**SUBJECT: BRES2109-0023**  
**BUILDING RESIDENTIAL**

Here are the results of all Inspections located at **685 WEST RD:**

01 FOUNDATION PLAN
 1/4" = 1'-0"

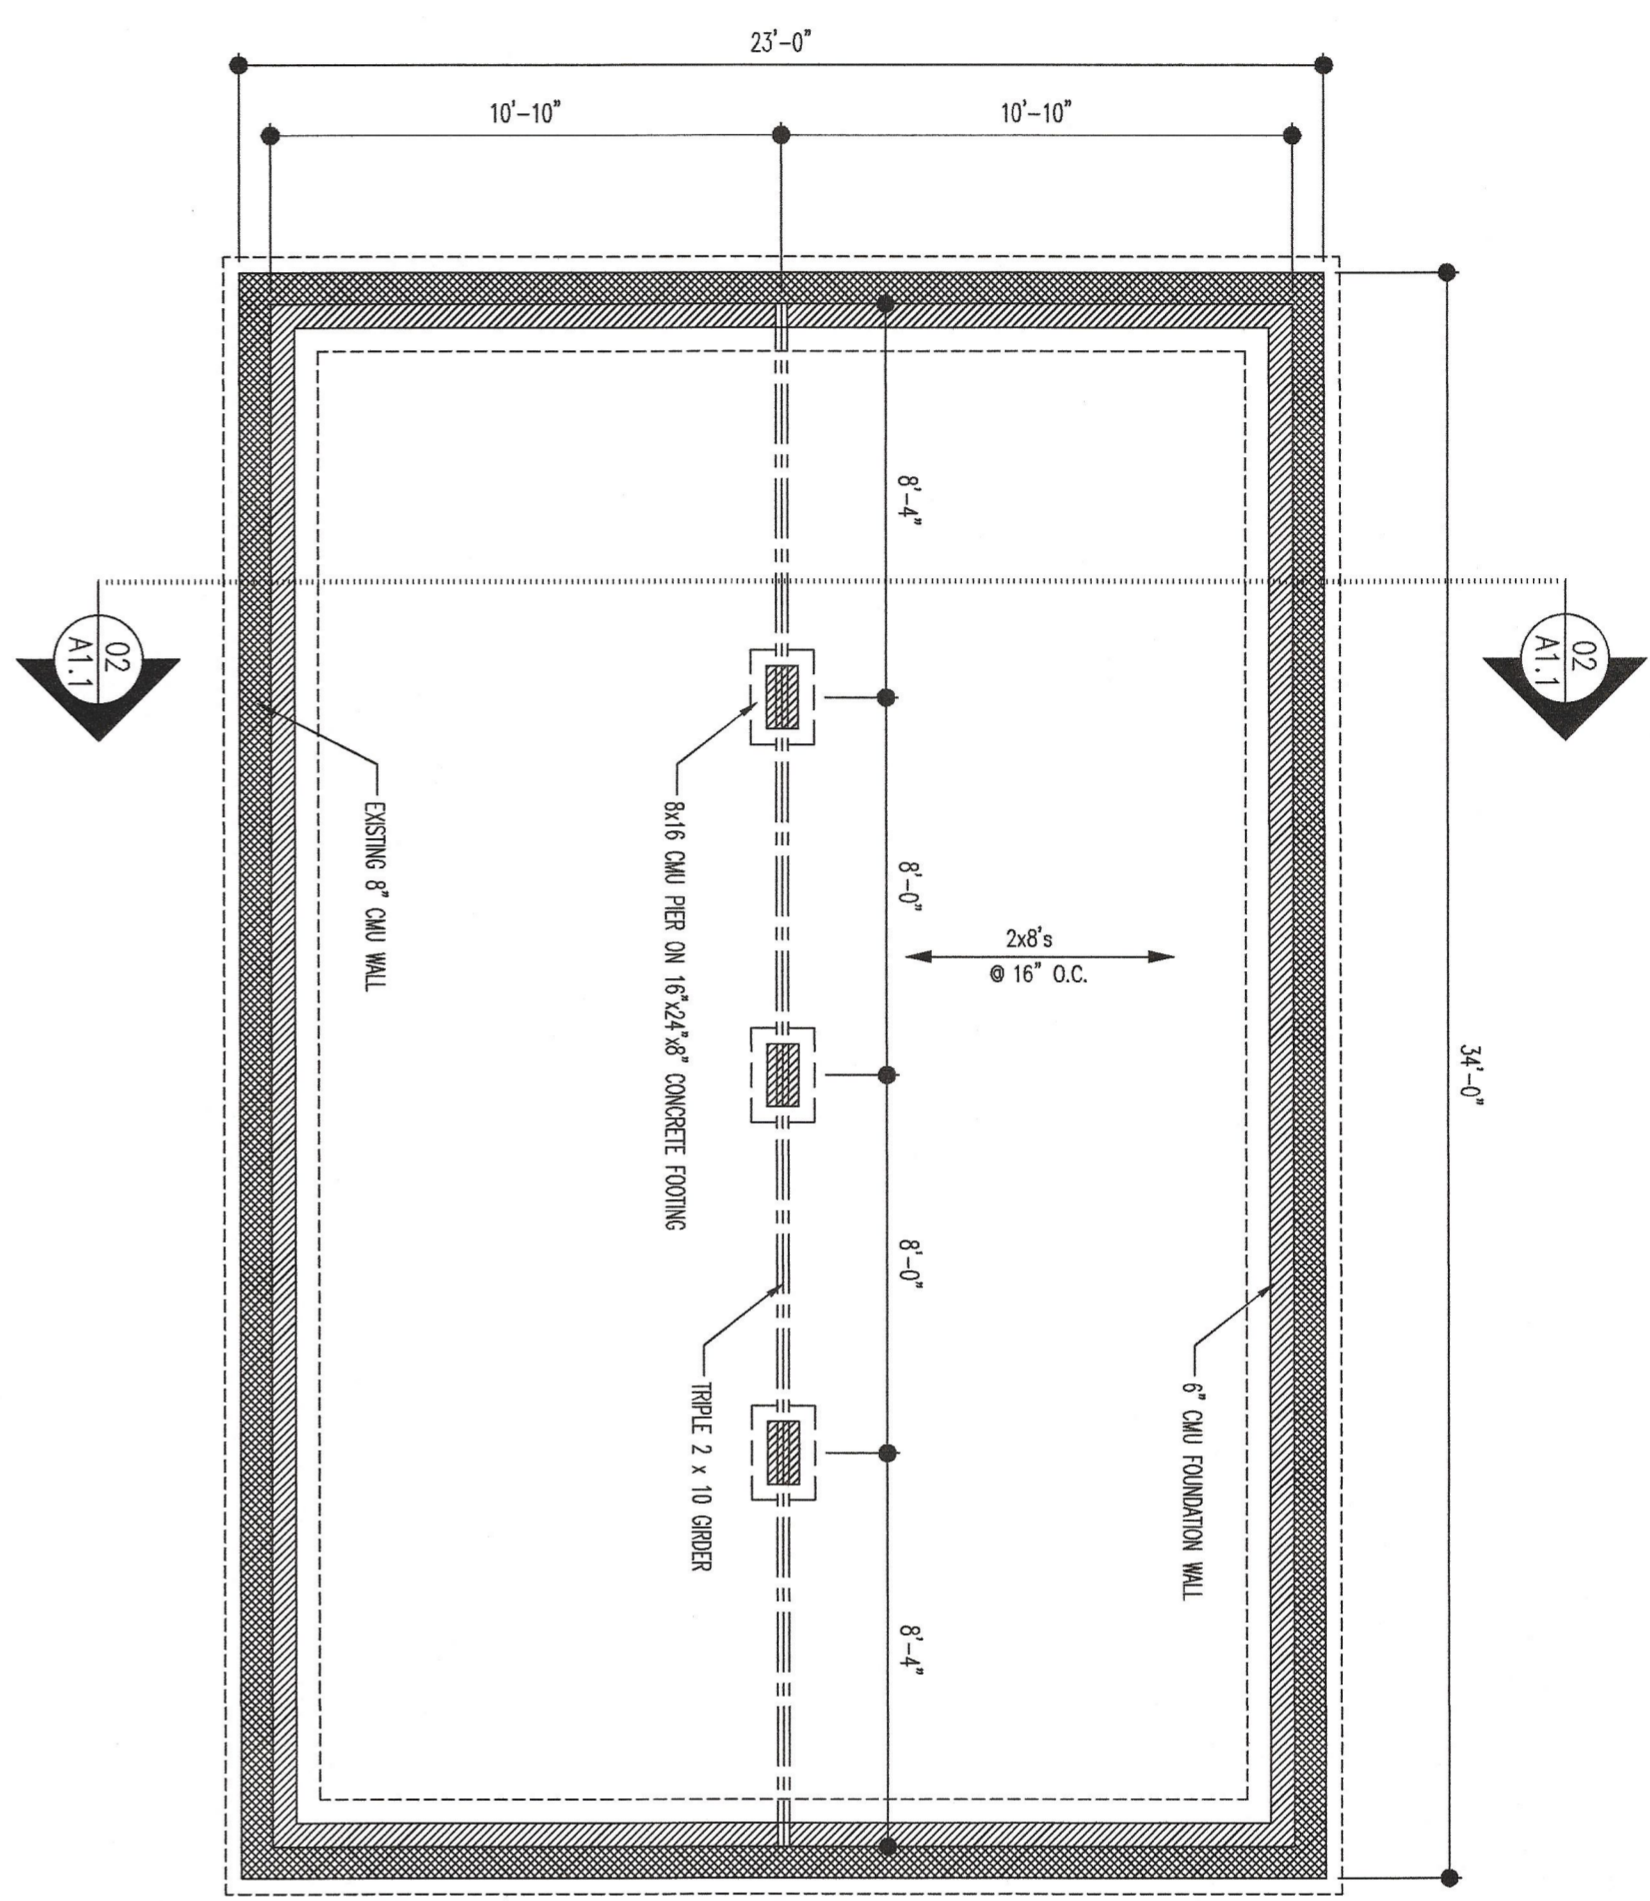
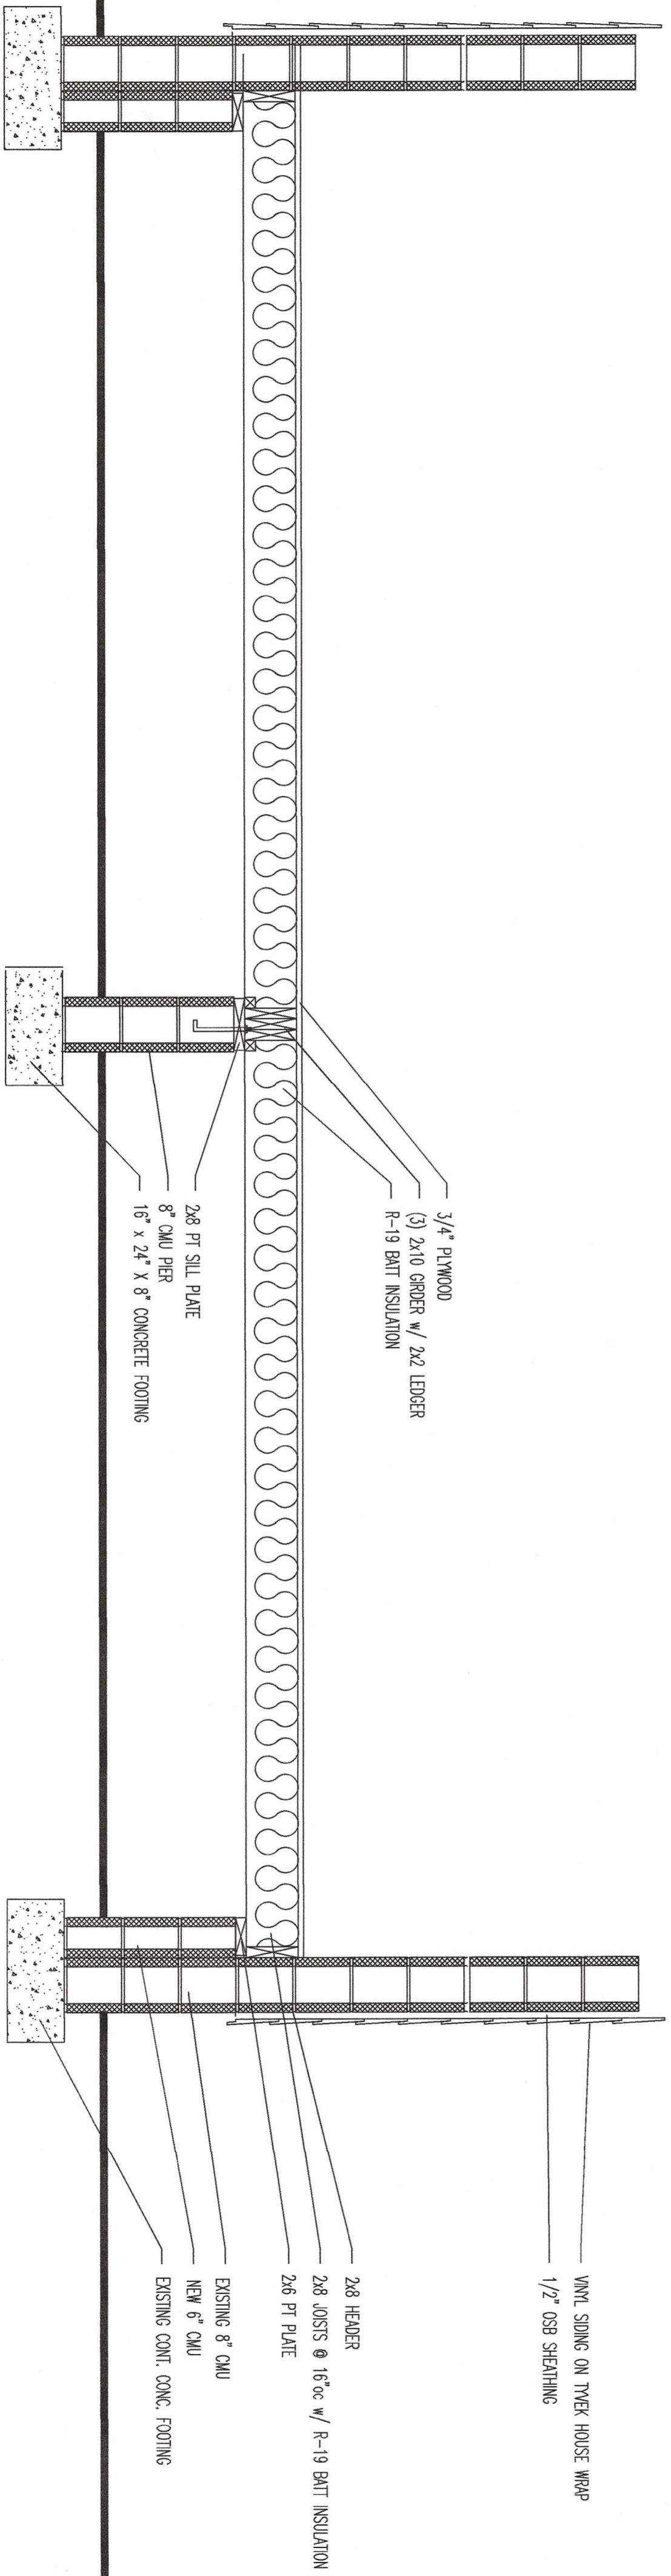
Foundation inspection never scheduled, provide engineering letter. Provide structural engineering letter on existing block wall. Replace broken pier blocks. Girder splices must occur over piers. Floor system must be treated or remove soils to 18 inch minimum below joists. Need 18x24 crawl access. Need foundation vents within 3 foot of corners. Replace hanger nails with 3.5 16d, or provide engineering. Anchor bolts missing in sill.

lock box code 6253  
Provide engineering letter on foundation.
